Department of Transportation

August 31, 2026

RE: Trinity Ranch Preliminary Plan (SP268)

TRINITY RANCH  
EL PASO COUNTY, COLORADO  
PRELIMINARY PLAN  
EXISTING DRAINAGE MAP

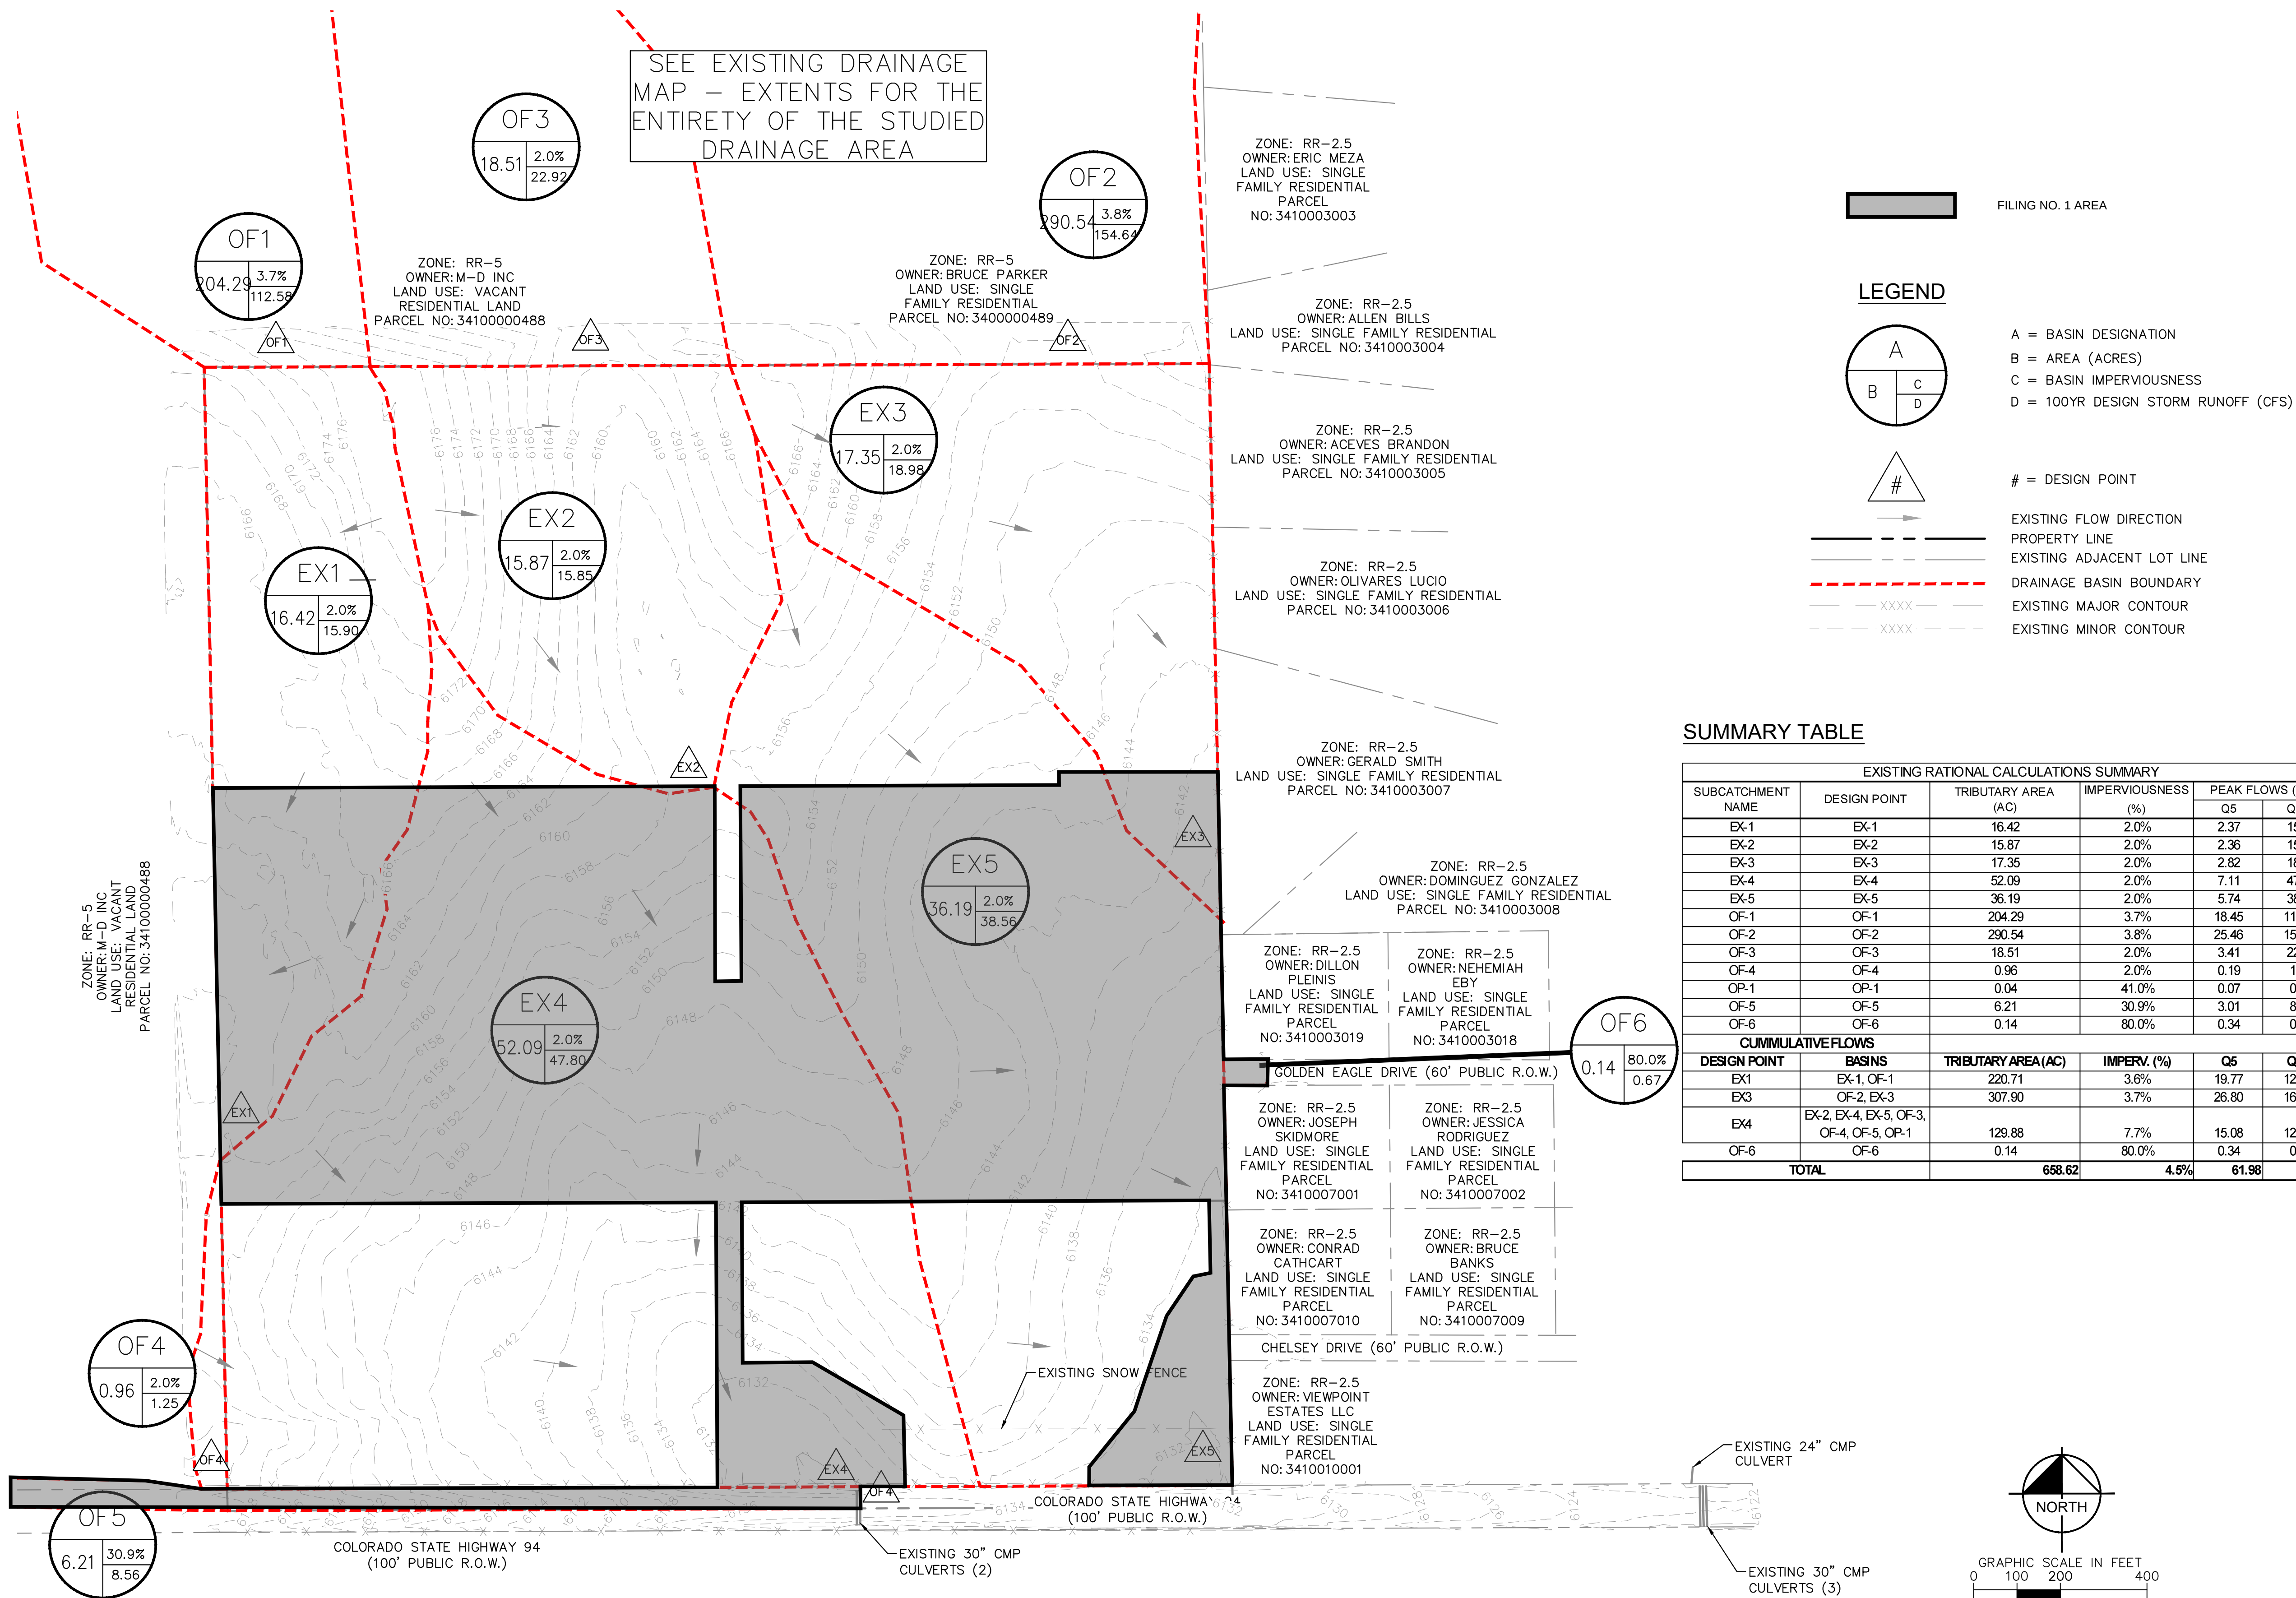
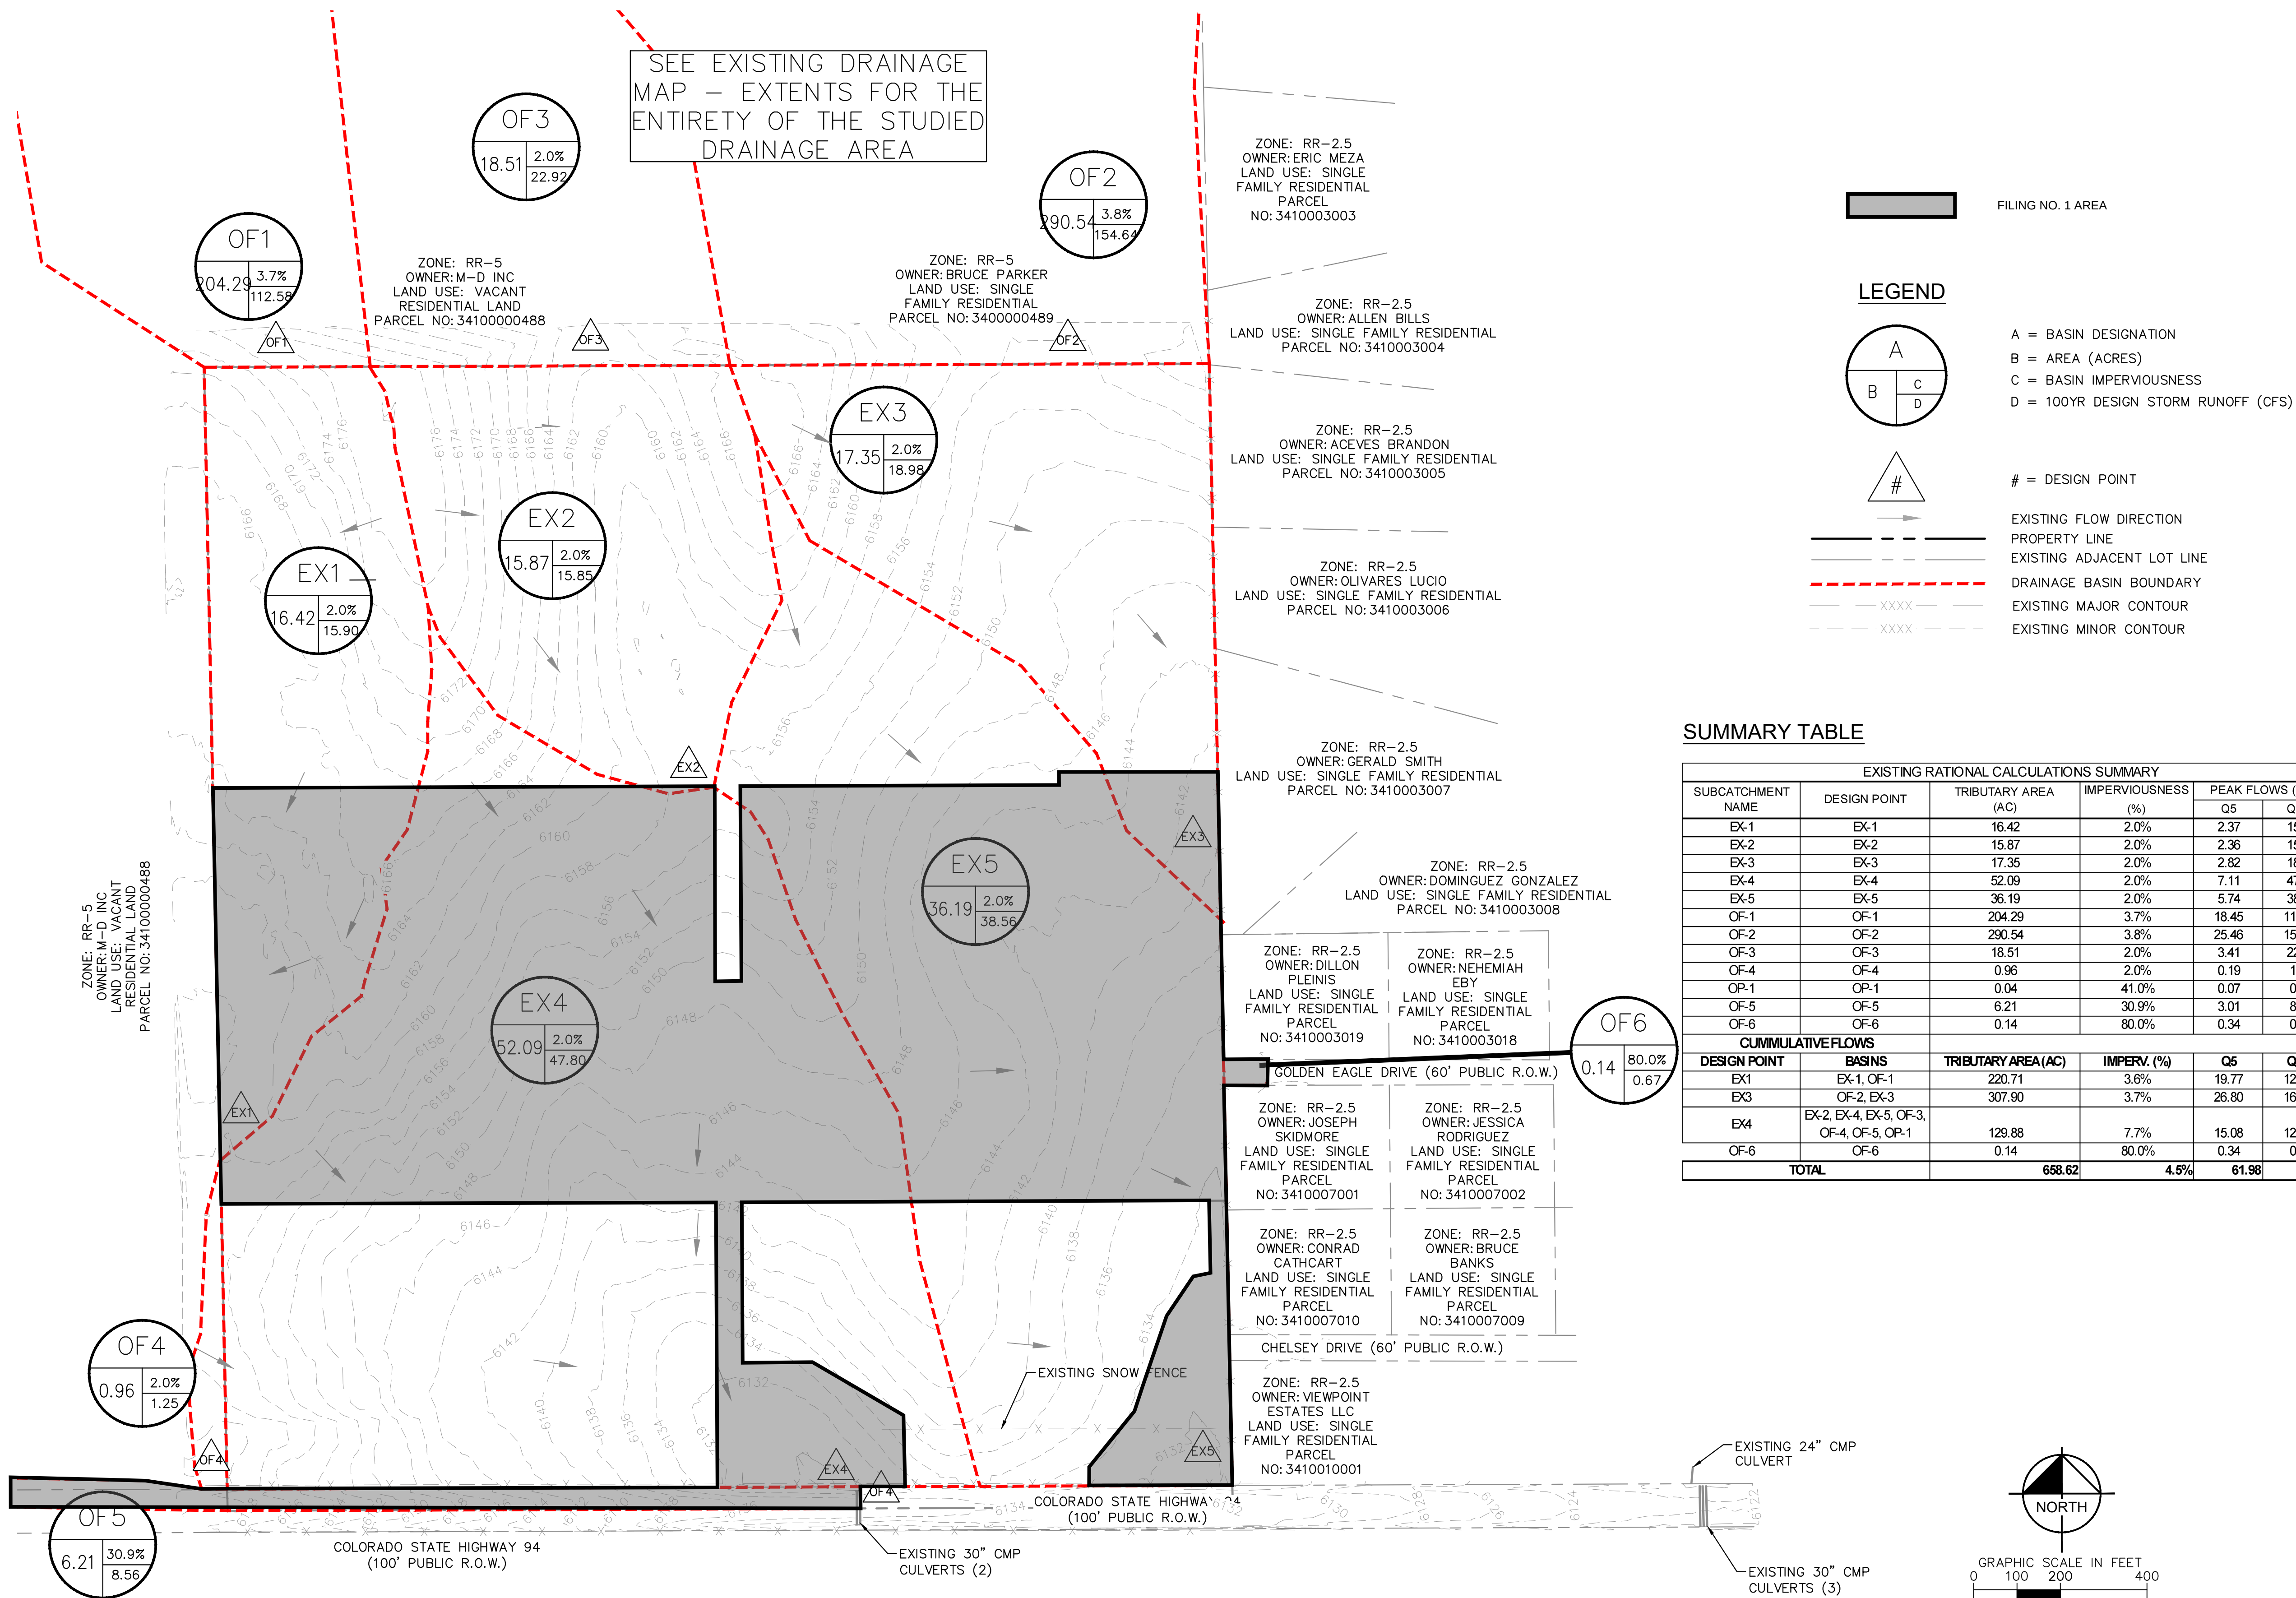
- FYI – PDF pg 82 – OP-1 missing from the drainage map.
- PDF p 82 – The Q100 for EX 5 is 38.56 cfs, the same location is identified as PR9 in proposed and shows an increase in Q100 to 61.78 cfs. Include ditch and culvert analysis to verify impacts to the CDOT ditch and to the 3-30" CMP culverts east of PR9 when the pond is overtopped.

- PDF p 82 – The Q100 for EX 4 is 127.17 cfs, the same location is identified as PR8 in proposed and shows an increase in Q100 to 155 cfs. Include ditch and culvert analysis to verify impacts to the CDOT ditch and to the 2-30" CMPs under the highway when the pond is overtopped.
